# CITY OF ALBUQUERQUE

**Re: 4Hg-LLC- Alteration Level 2  
10520 Research Rd SE  
30-Day Temporary Certificate of Occupancy  
Transportation Development Final Inspection  
Engineer's/Architect's Stamp 11-20-19 (M21D022)  
Certification dated 3-11-20**

BIKE RACK DETAIL  
N.T.S.

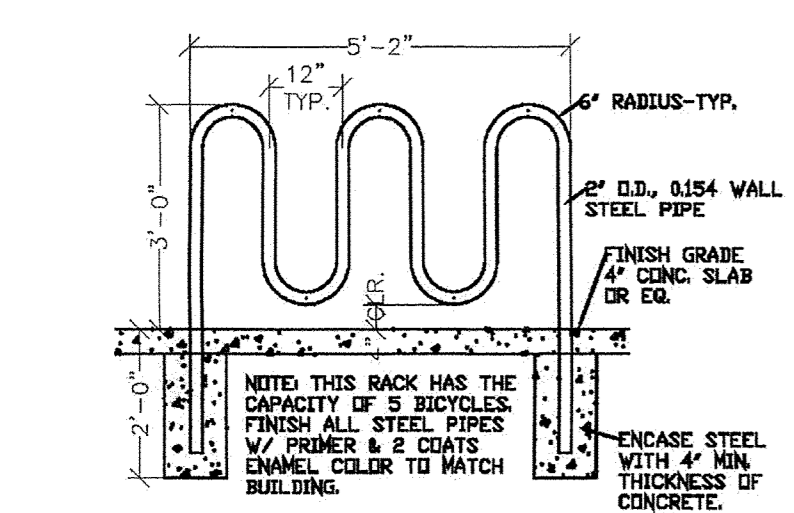
- Please relocate Bike Rack out of ADA access. (See attached Photo)
